STATE OF NORTH CAROLINA  
DEPARTMENT OF TRANSPORTATION

**Addendum No. 2**

RE: Contract # C204058  
WBS # 44475.3.6, 44475FHWA.3.1  
F. A. # STBGDA-1001 (79)  
Mecklenburg County (P-5705BA, BB)  
Charlotte Gateway Station

**May 29, 2018 Special Letting (Advertisement extended from May 15, 2018 Letting)**

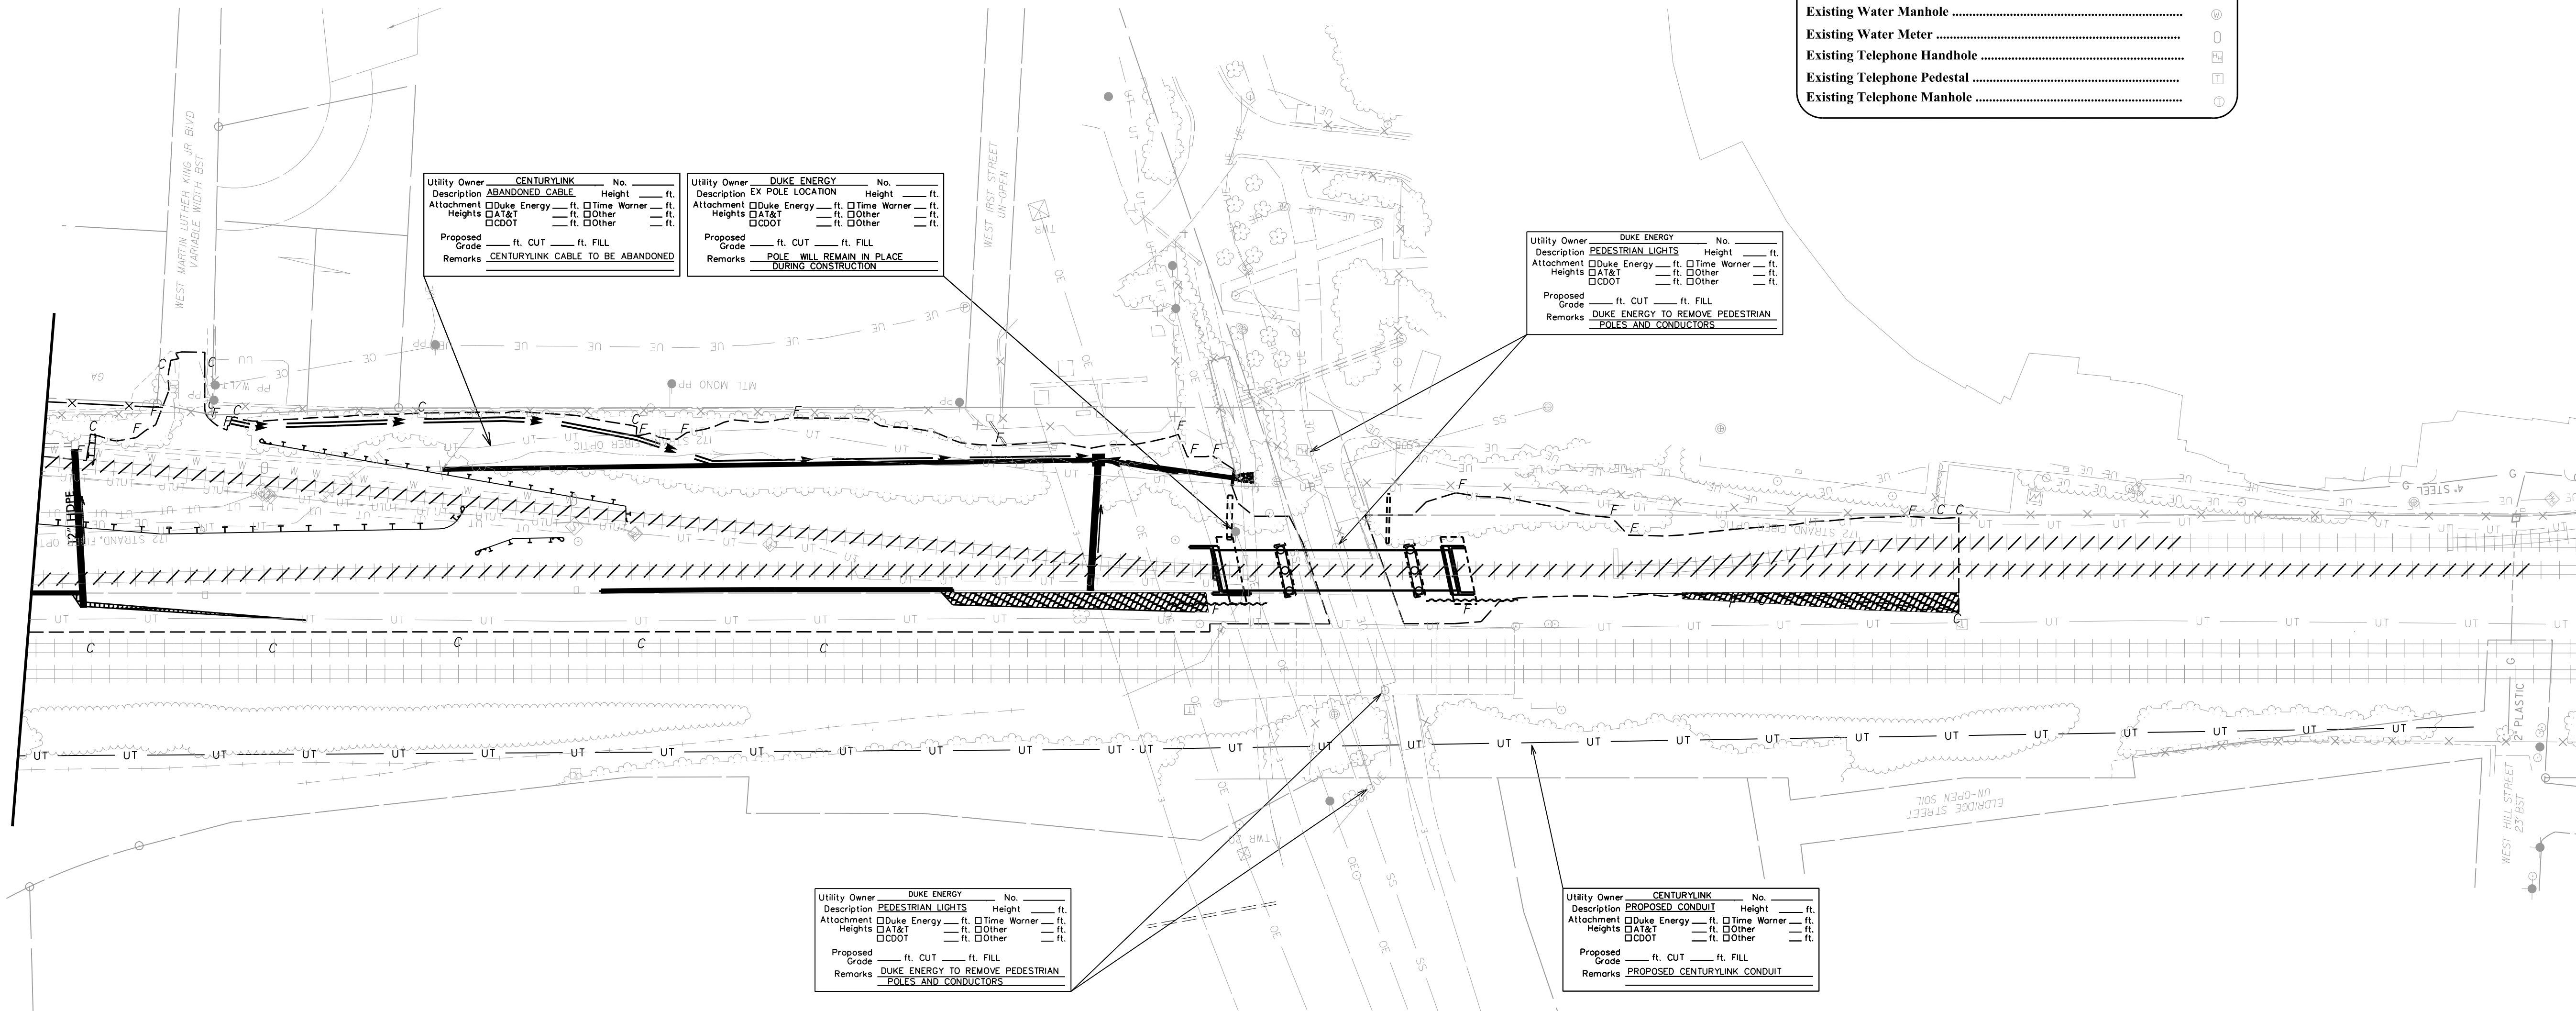
Sheet No.	Revisions
Title Sheet 1	Revised the letting date on the combined title sheet for "BA" & "BB"
Title Sheet 1	Revised the letting date on the title sheet for "R-5705 BA"
UO-02	Revised to note that utility owner "Zayo" is not in conflict
